WELWYN HATFIELD COUNCIL – DEVELOPMENT CONTROL
WORKS TO TPO TREES DELEGATED REPORT

APPLICATION No:	<u>N6/2009/1857/TP</u>
LOCATION:	19 Scholars Mews, Welwyn Garden City
PROPOSAL:	<u>Crown lift hornbeam tree (T10) above window,</u> <u>crown lift oak tree (T11) and thin by 20% and thin</u> <u>two hornbeam trees (T12 &T13) by 20%</u>

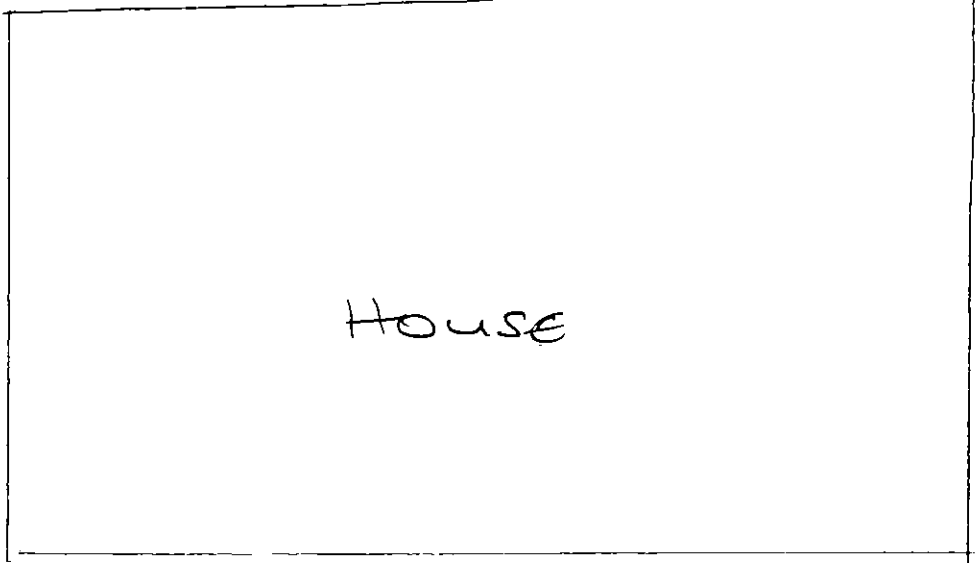
The Hornbeam (T10) in question is to the front of the property has been crown lifted in the passed. The applicant wishes to crown lift to the approximately the same

height which is 5m - window height. As this work has been carried out before it would be acceptable.

The oak (T11) is mature which has also been crown lifted in the past. The applicant wishes to crown lift the tree to the same height as the adjacent hornbeam and thin the crown by 20%. The crown lifting work is similar to that which has been carried out in the past. The thinning work would allow more light to the has, which is what the applicant would like, but would have little affect on the amenity value of the tree. If this work is carried out in accordance with current best practise it would be appropriate.

Two hornbeams (T12 and T13) are fairly leggy specimens along the boundary. The applicant wishes to thin these trees by approximately 20%. The applicant wishes to crown thin the tree by 20%. This work although not essential would have little effect on the amenity value of the trees.

RECOMMENDATION: APPROVAL WITH CONDITIONS
